**Application by NNB Generation Company (SZC) Limited for an Order Granting  
Development Consent for The Sizewell C Project**

**Procedural Deadline 3 Submission**

## Appendix A: National Trust technical comments on design details and plans for the Hard Coastal Defence Feature (HCDF)

DRAWING NO:
 SZC-SZ0100-XX-000-DRW-100263

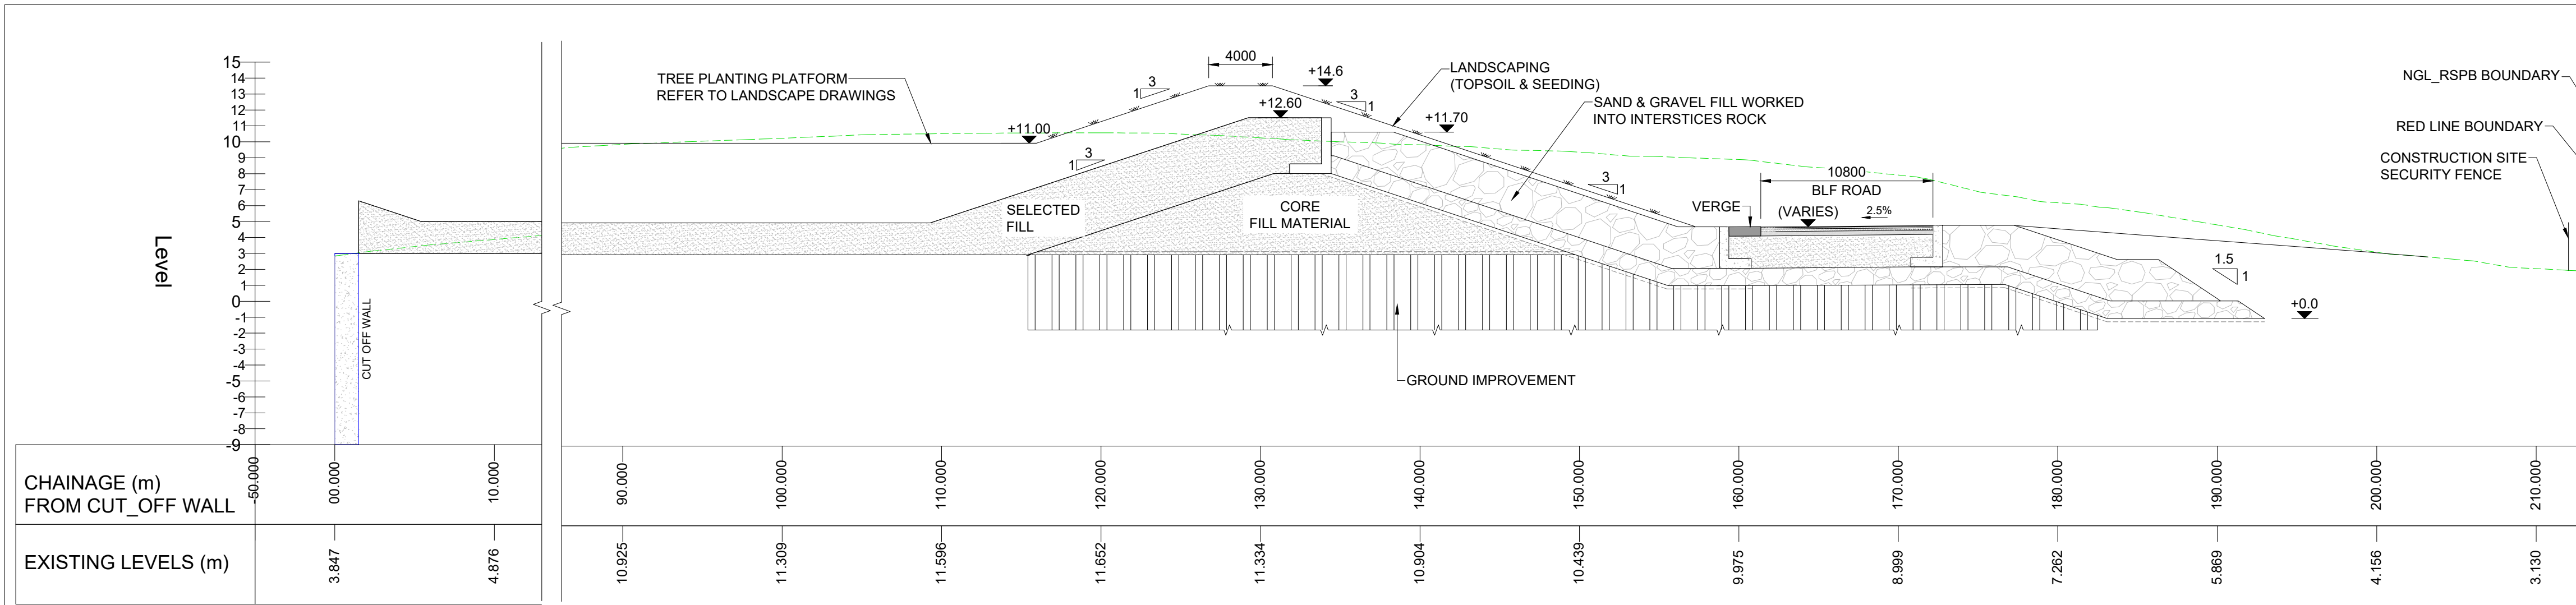
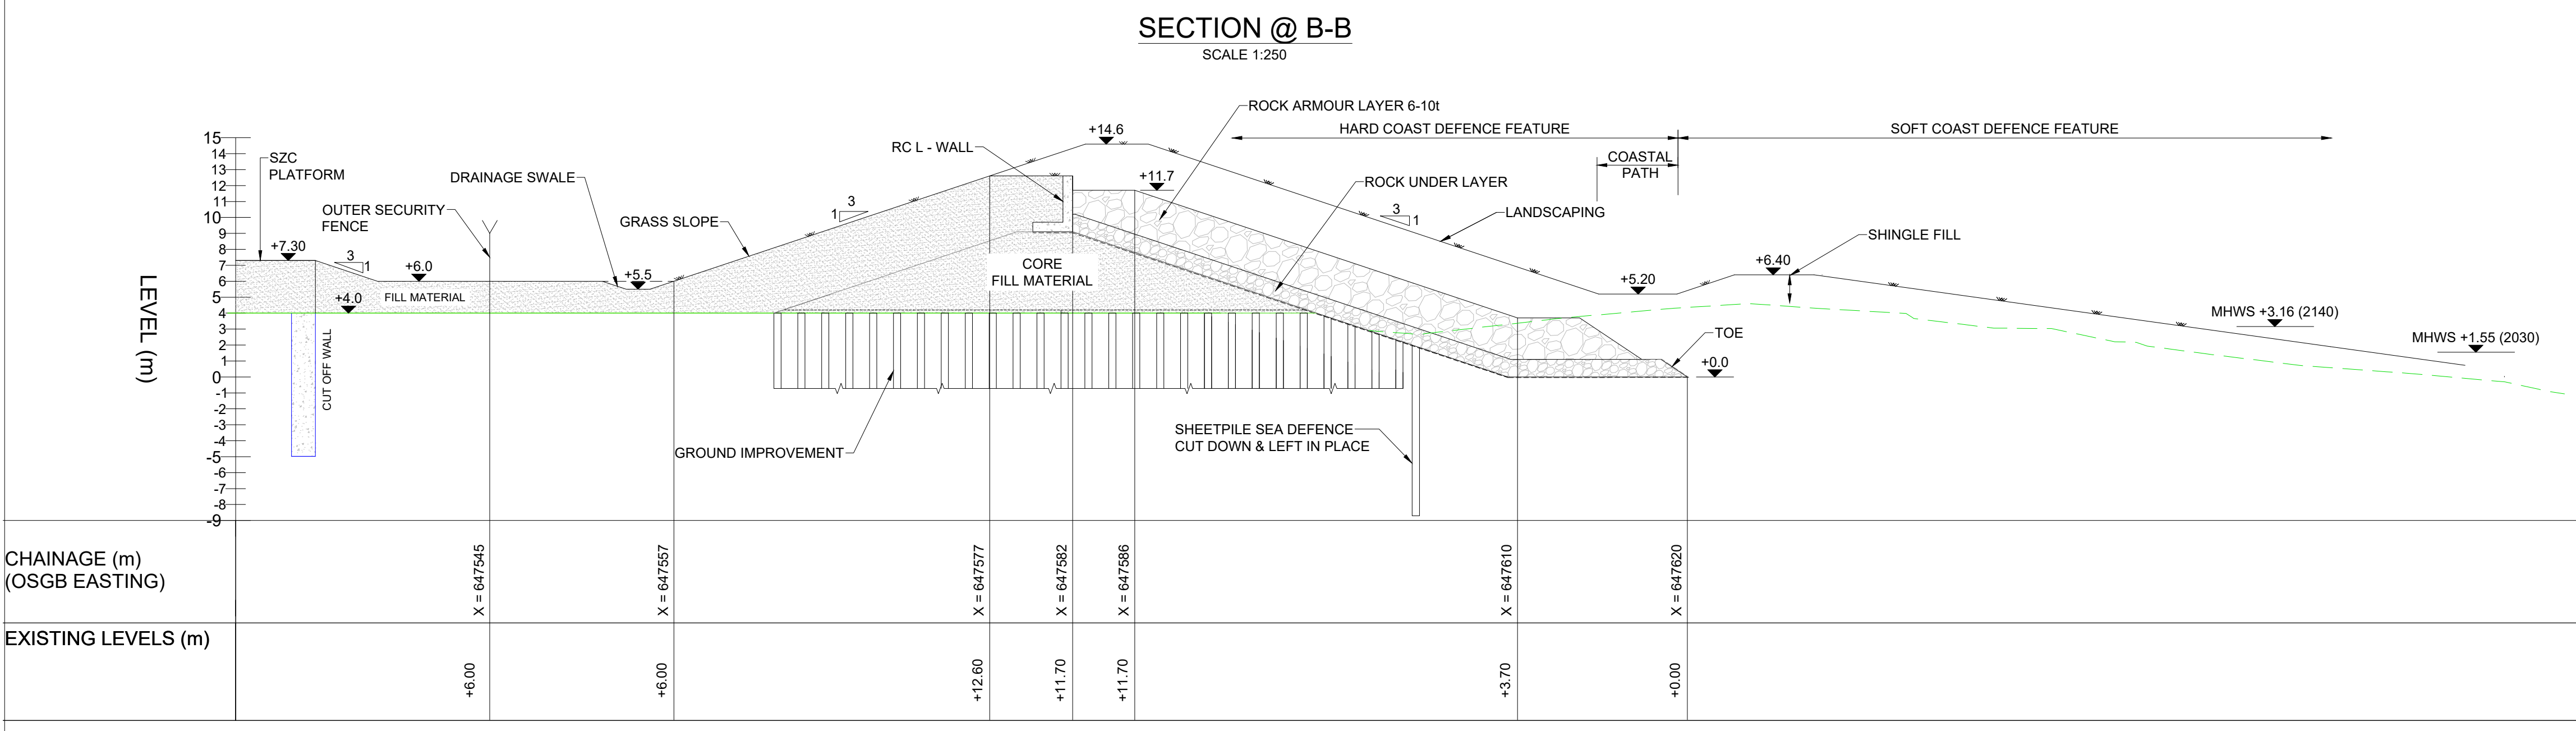
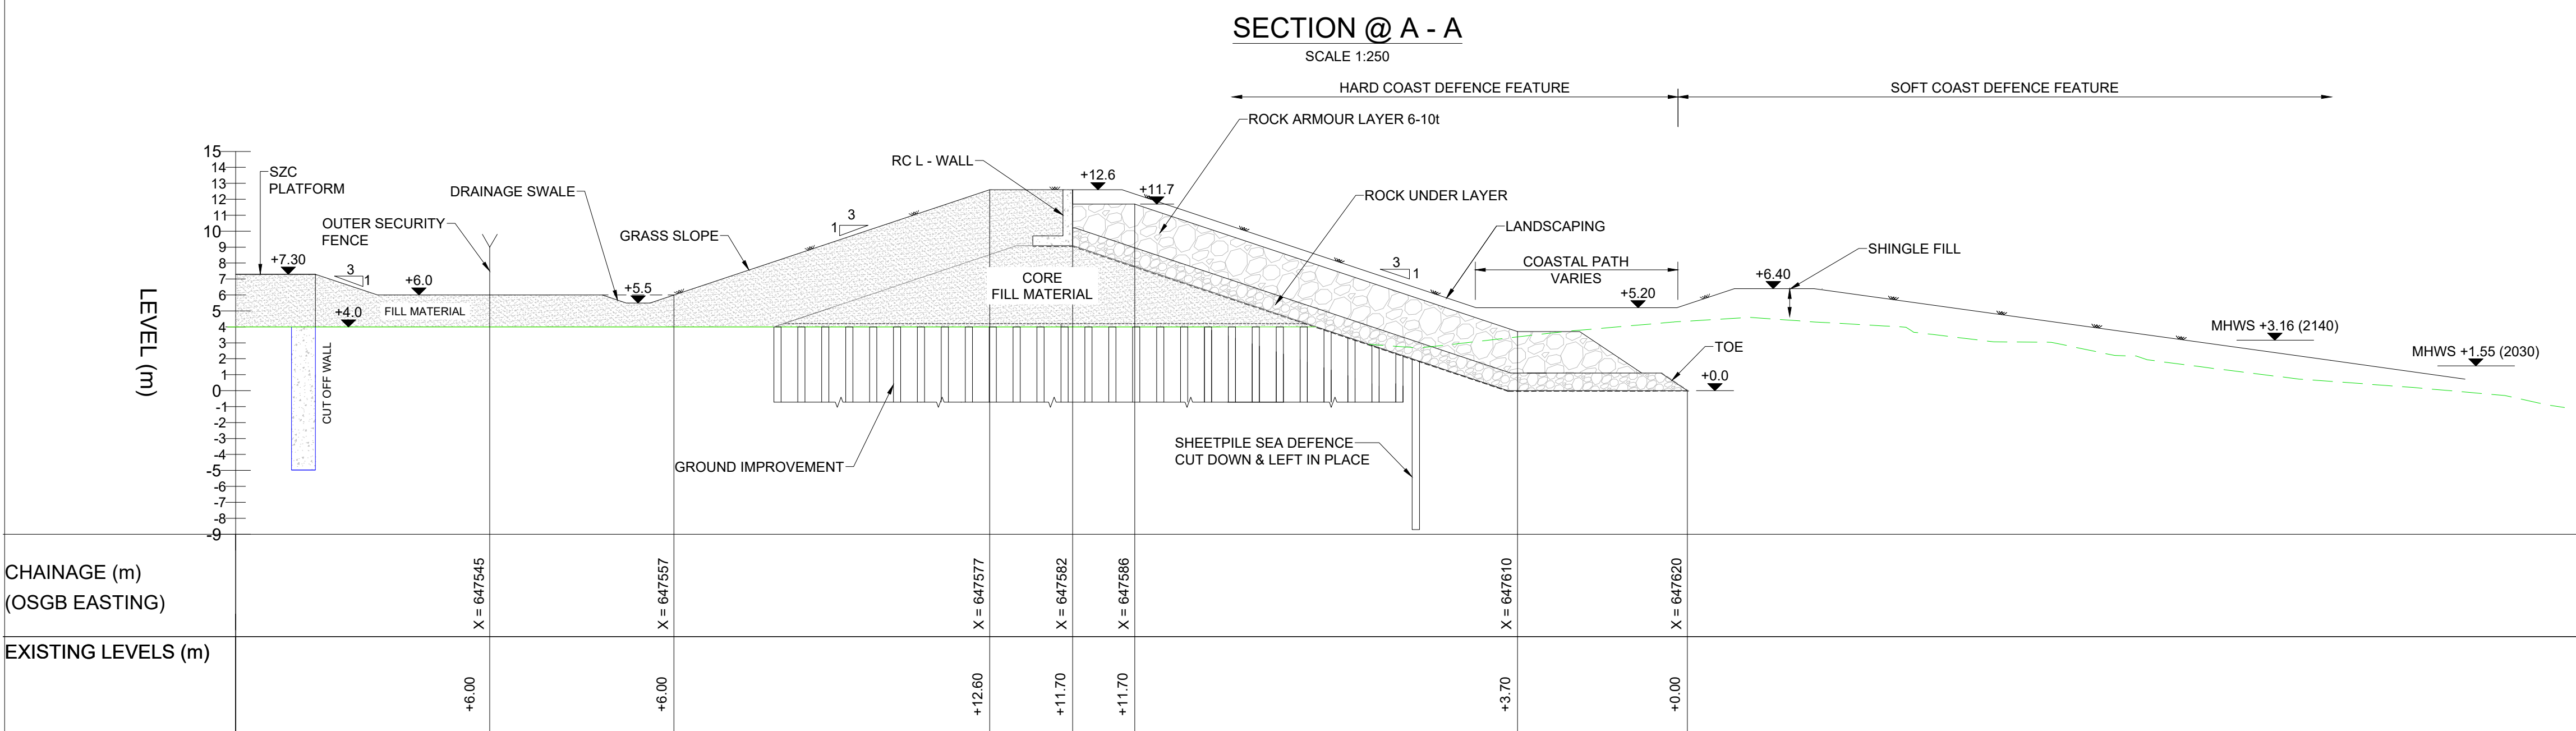
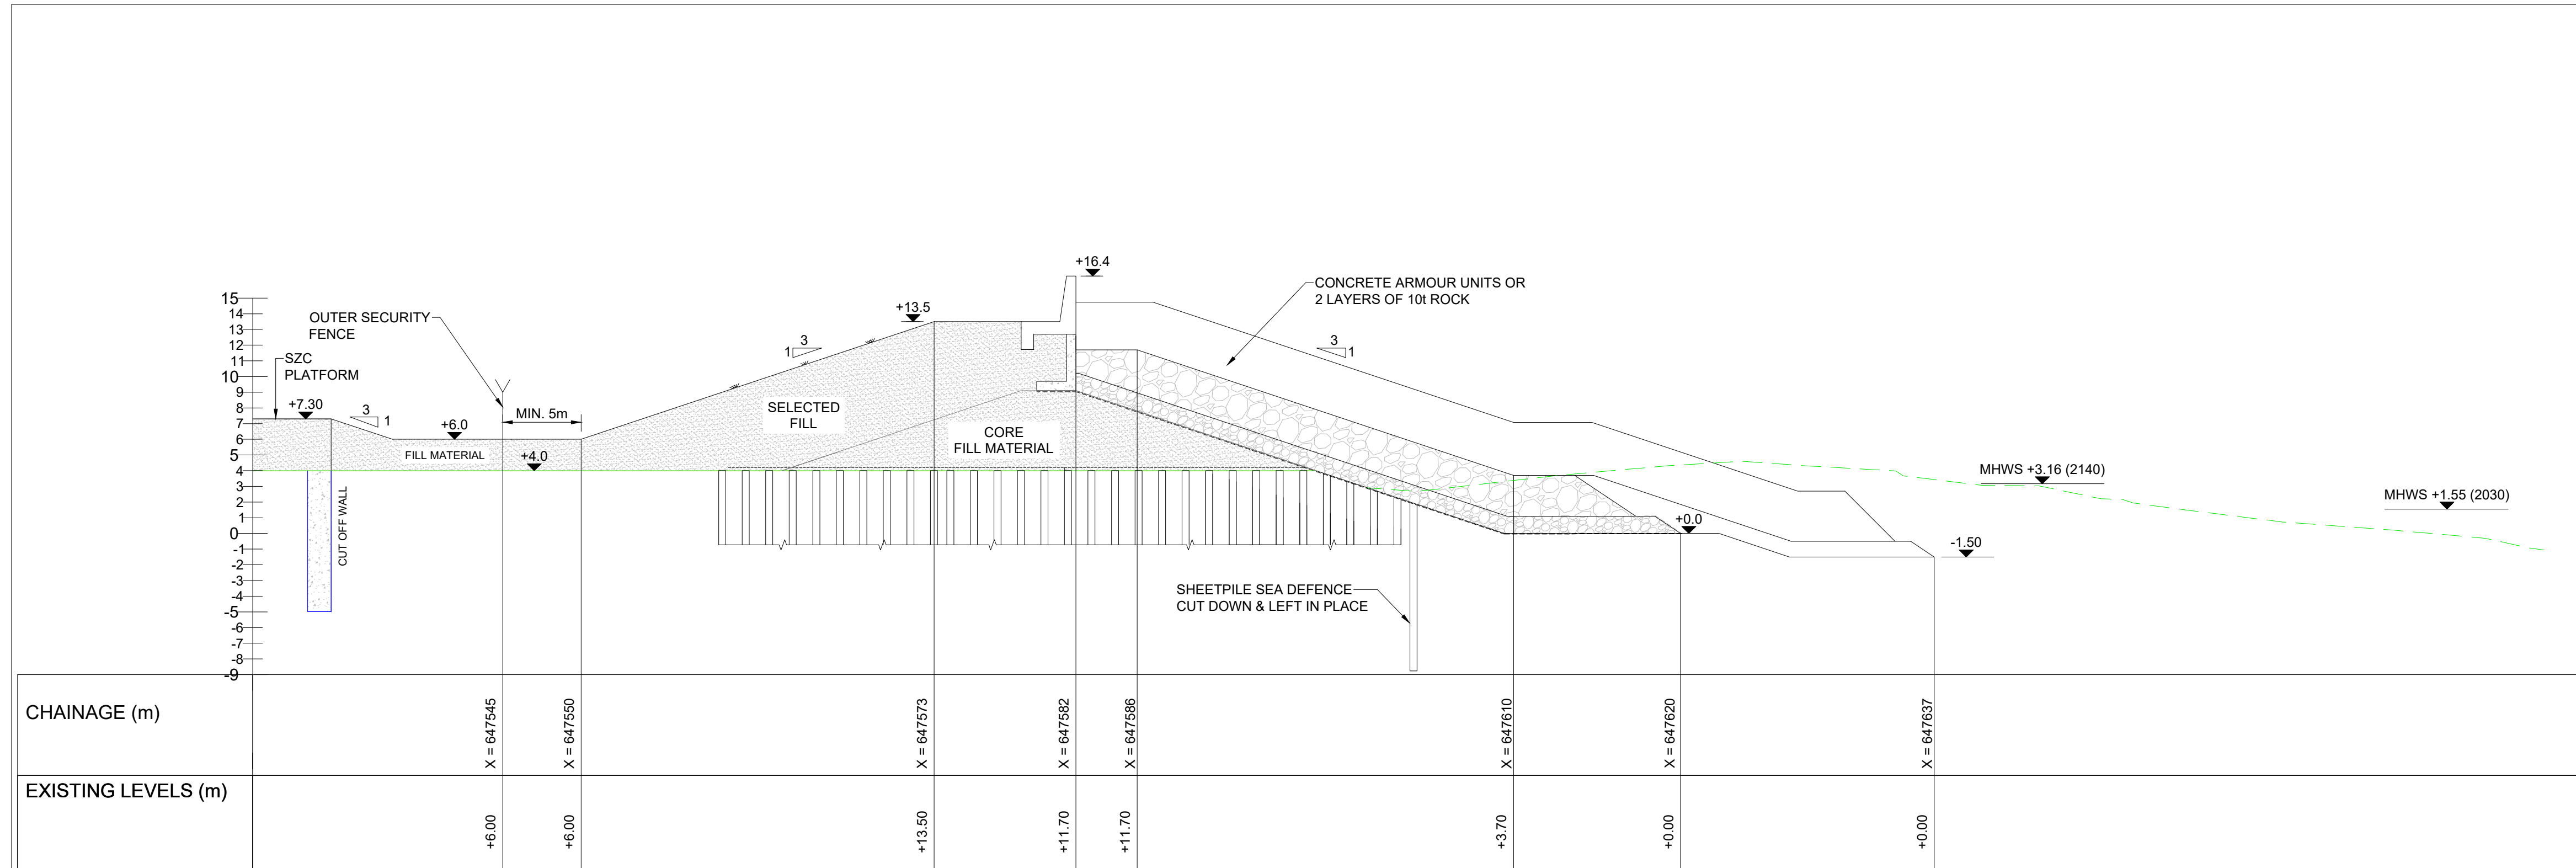
9. Table 3-4 summarises the changes made from the previous submission and shows a higher crest level (it is unclear the visual implications of this have been presented by the developer). It also shows a lower toe level (so the structure is further seawards than previously, apparently by around 8-10m).
